# CITY OF ALBUQUERQUE

**Re: Caliber's, Washington and Cutler. Grading and Drainage Plan  
Engineer's Stamp dated 11-2-11 (H17/D089)**

GRADING PLAN

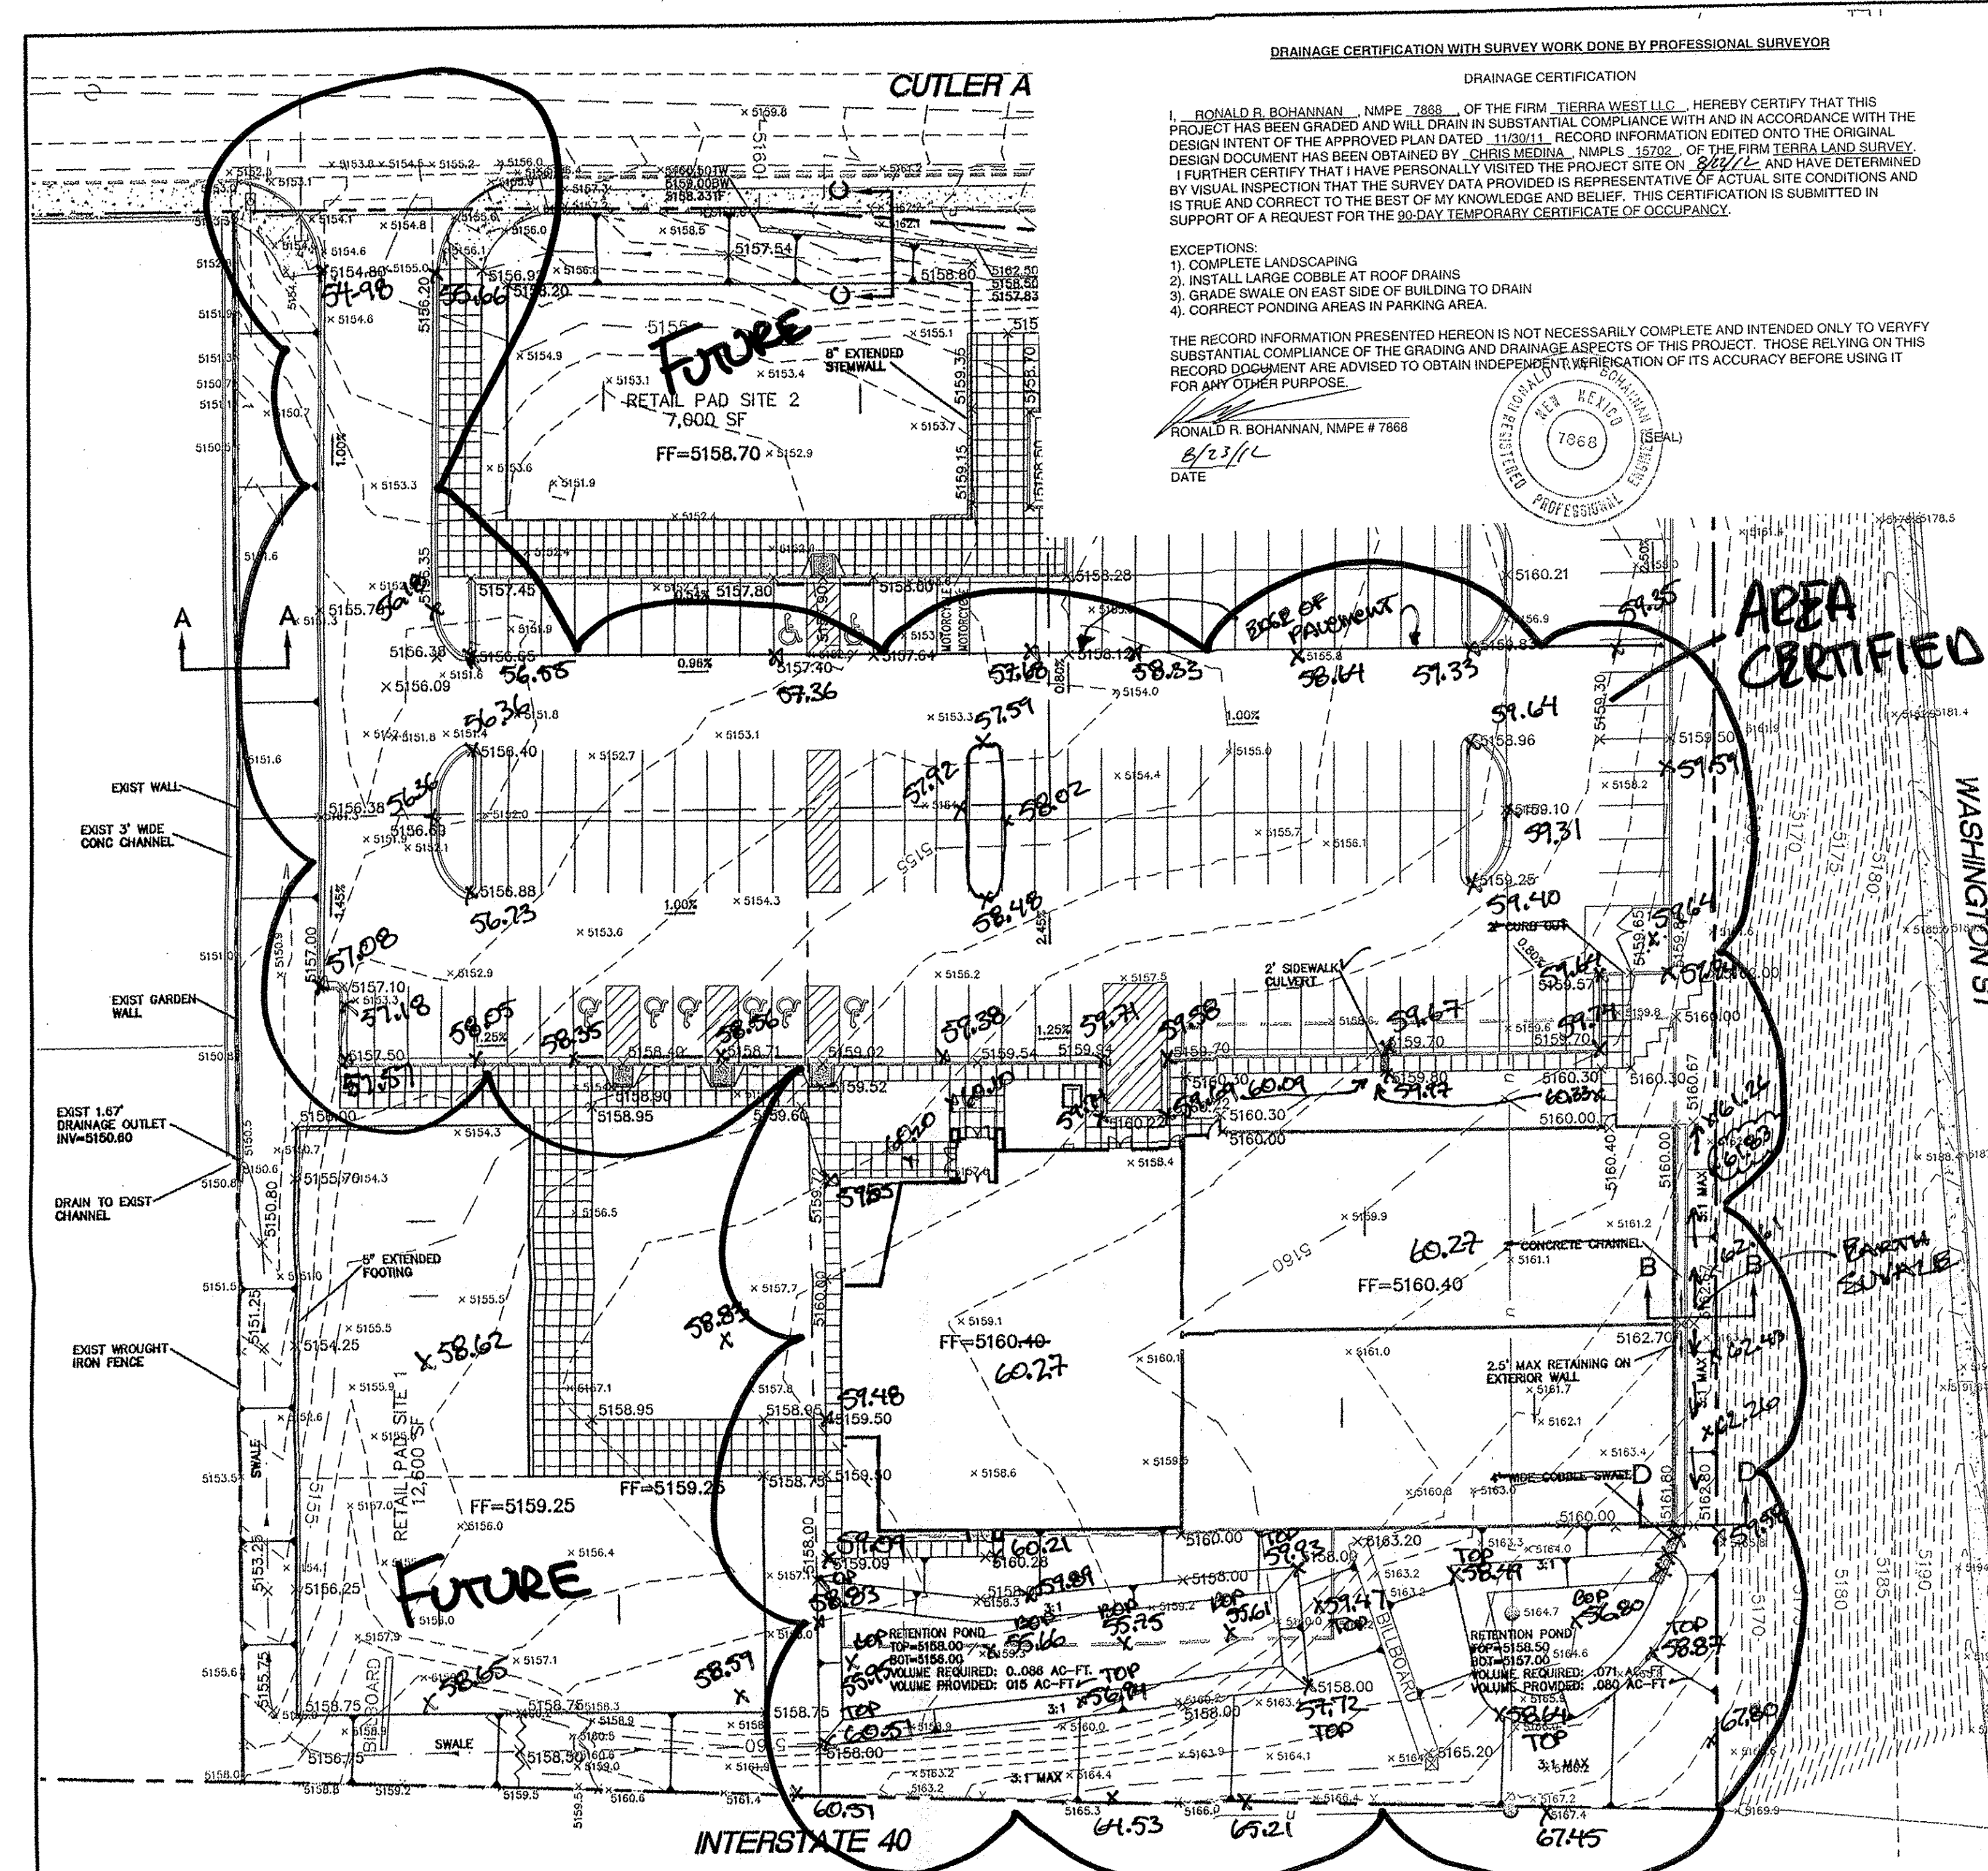
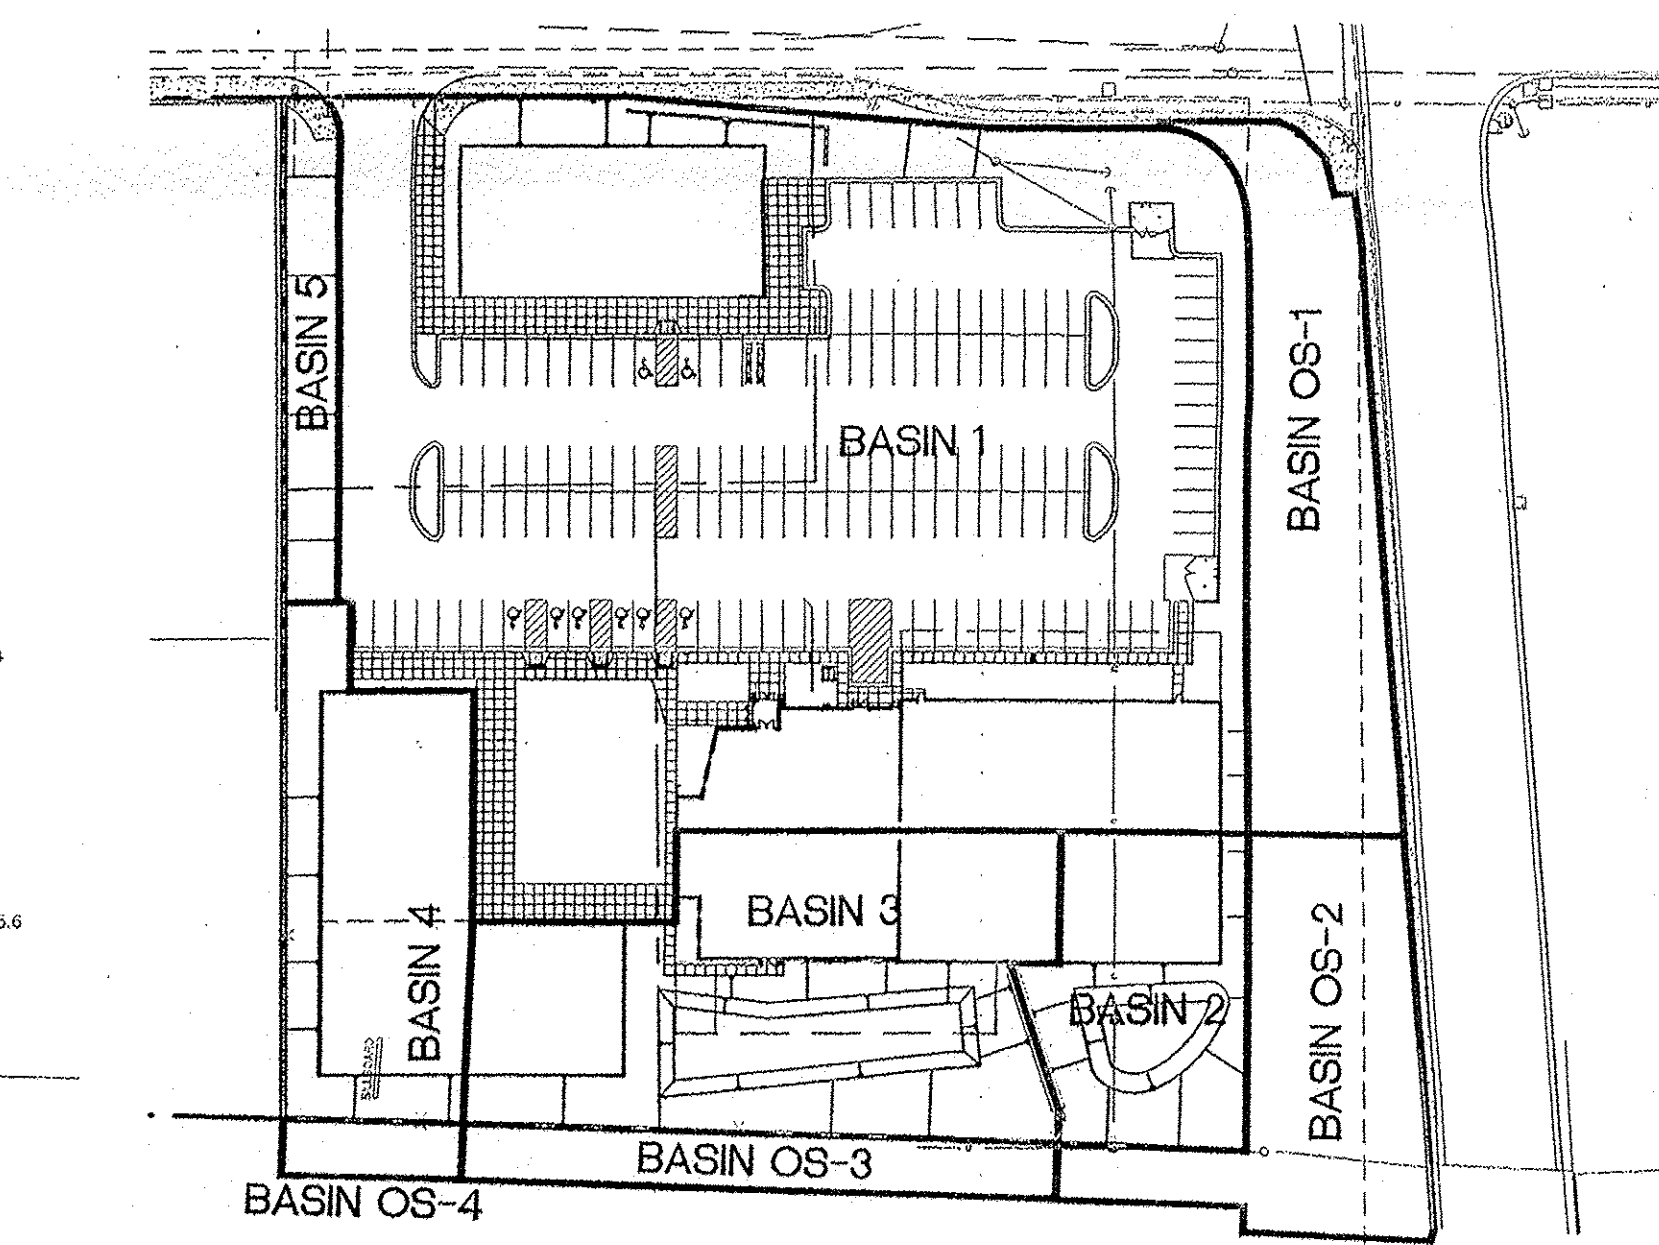
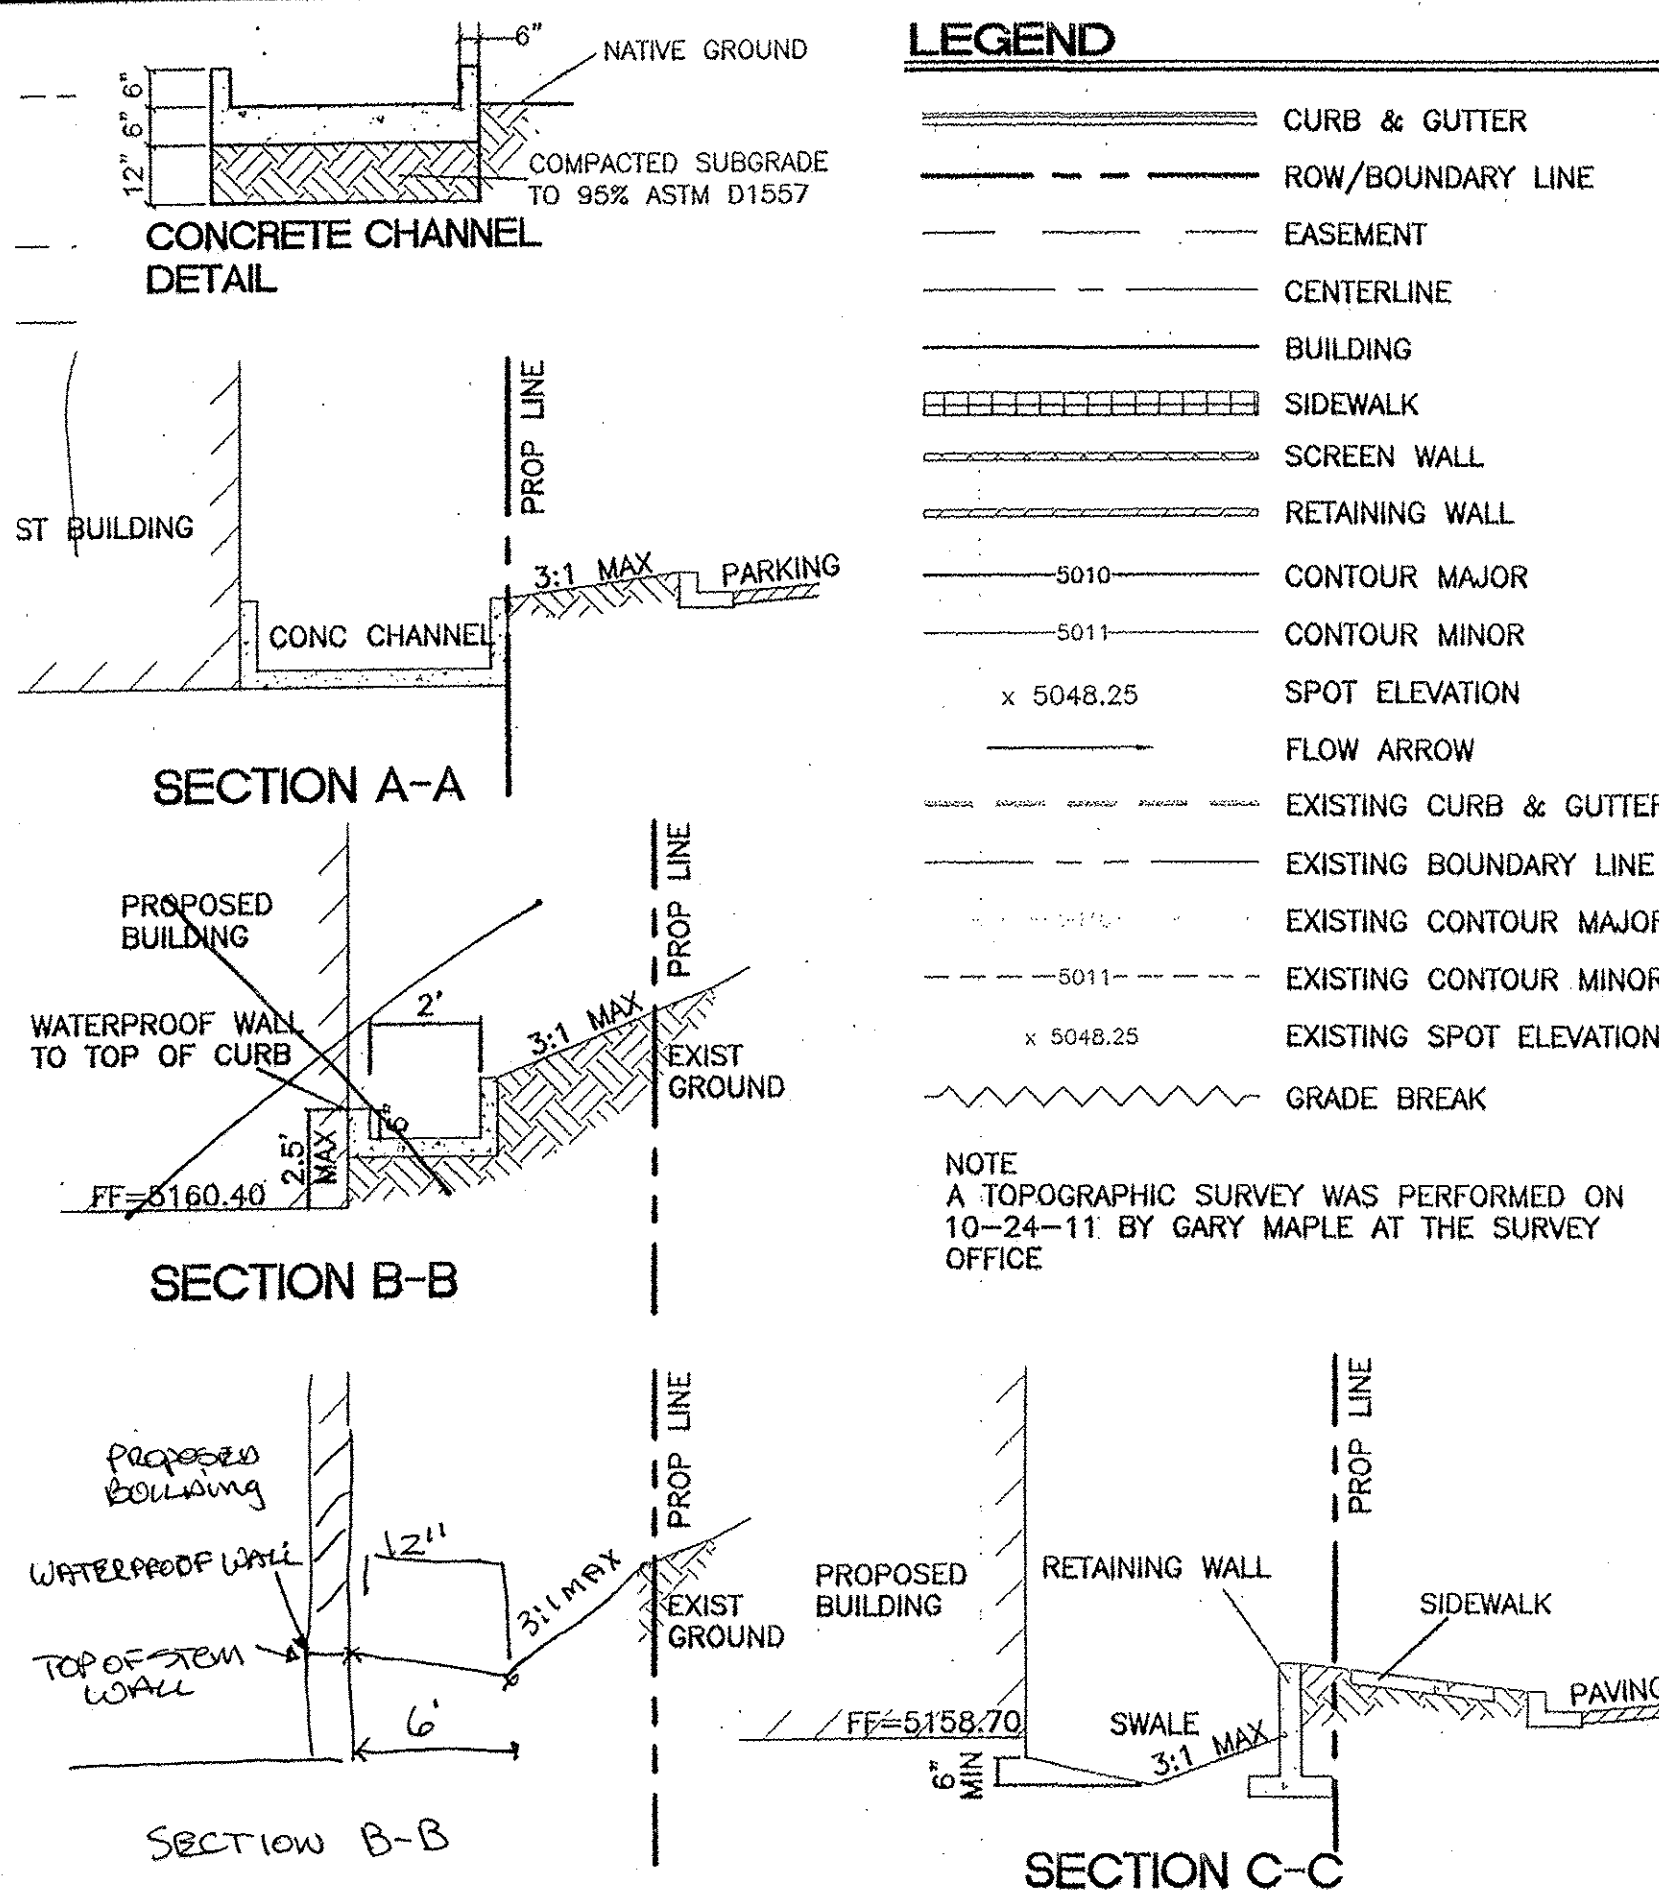
- Per site visit 11-18-11, existing grades at the site appear different than shown on the plan. Provide the date of the survey, the surveyor's name and existing spot elevations.

- Label the existing contours.
- The site has a "bowl" in the middle that ponds a large portion of existing flow, contrary to the statement in the "Existing Drainage" narrative.

- Show the garden wall south of the "Drain to Exist Channel".
- Provide grades along the west boundary to aid in the determination of the slope and swale.

- Sections A-A, B-B, and C-C are translated horizontally.
- Please confirm the size of the "Exist 2' Drainage Outlet". It appears to be 18" wide.
- Provide depths and side slopes of swales in Section B-B and C-C.

- Provide the allowable flow to the site to the west from that site's grading and drainage plan.
- It is not evident that Basin 4 will discharge to the parking lot. Provide details for the swale.

- Provide steepness of proposed slopes on the north side of the property.
- Provide flow line elevations in Cutler Ave near the drive entrance.
- Additional comments may be produced once existing grade data is provided.
